Sent: 07 October 2013 17:26
To: Planning
Subject: Welwyn Hatfield Council Online Planning - Comment

Application Number: N6/2013/1938/MA

Comment: I object to this application on the following grounds.

Title Existing / Proposed Elevations
 Sheet 1 of 3

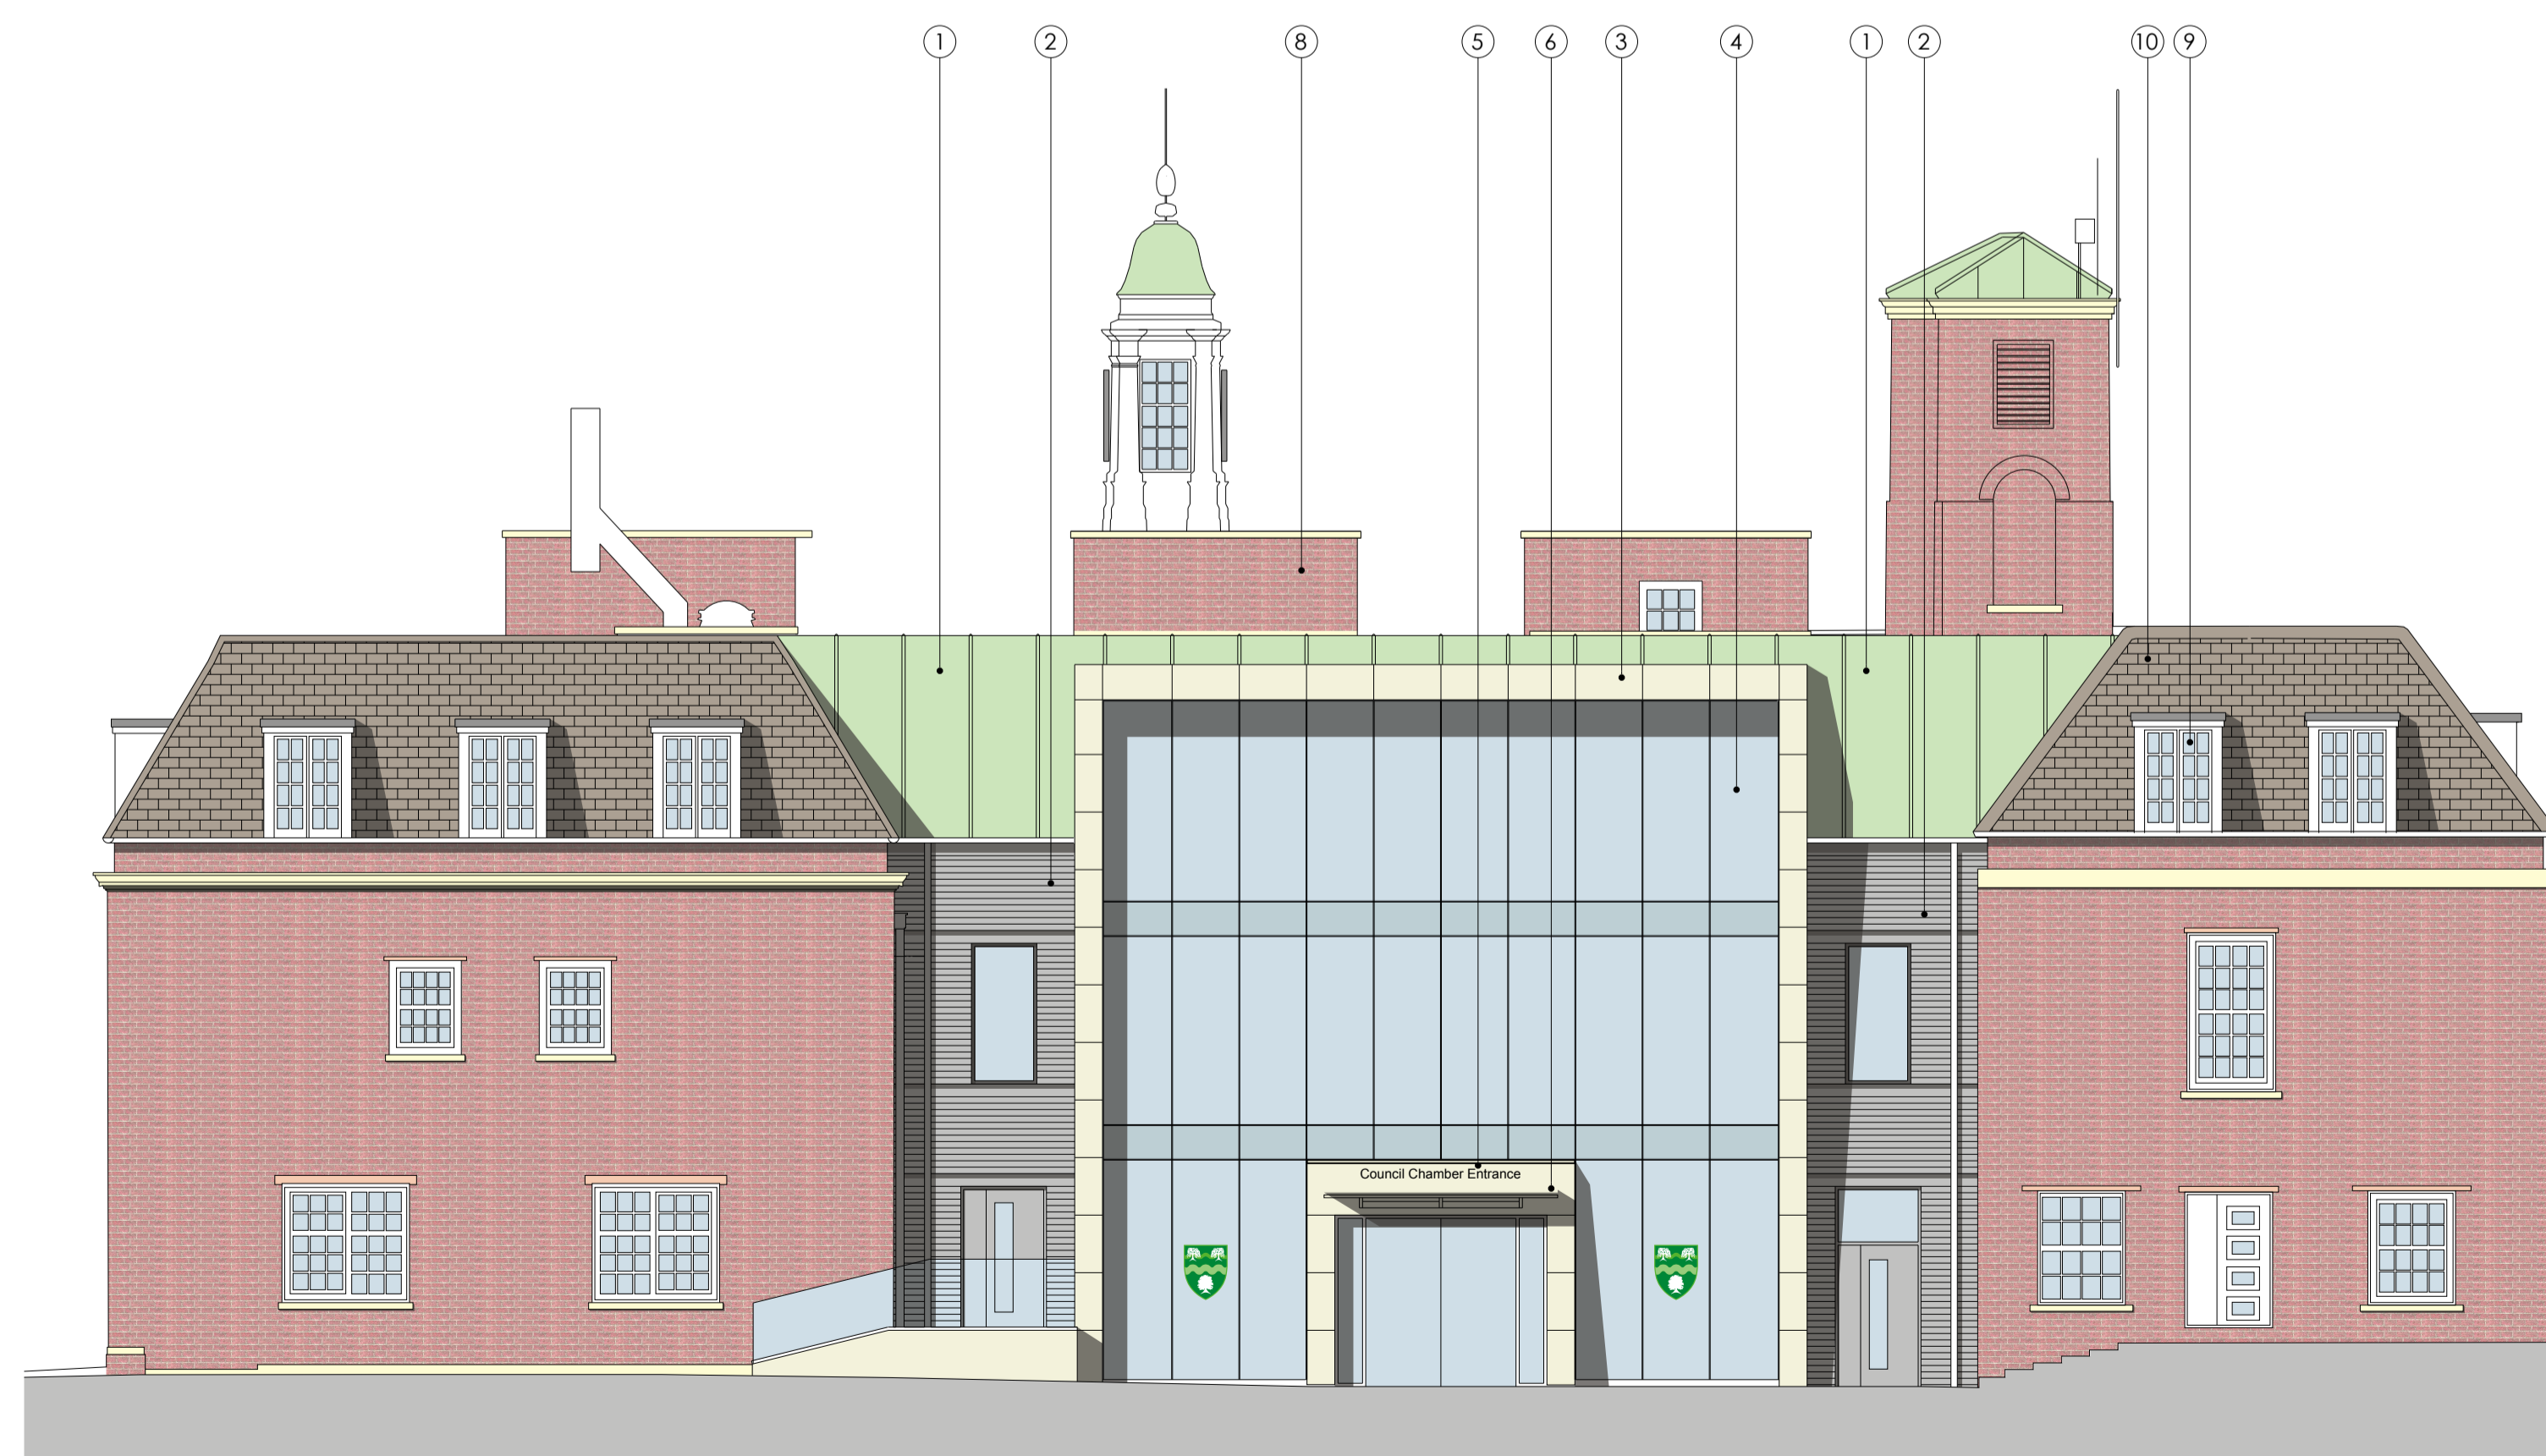
- a.) The quality of the design of elevational treatment is extremely poor in relation to the quality and materials of the existing buildings. The impression that the drawings give is that the designer has little knowledge or skill in using a contemporary architectural style in the context of a more traditional existing building and setting. I doubt if the Council would approve a similar design solution if presented by private applicant in the Welwyn Garden City Conservation Area.

- b.) I am not against a modern design solution to the extension problem if it is done well by skilled architects. This scheme demonstrated that the designer has little or no understanding of the importance of the ethos and nature of the Garden City in architectural terms.
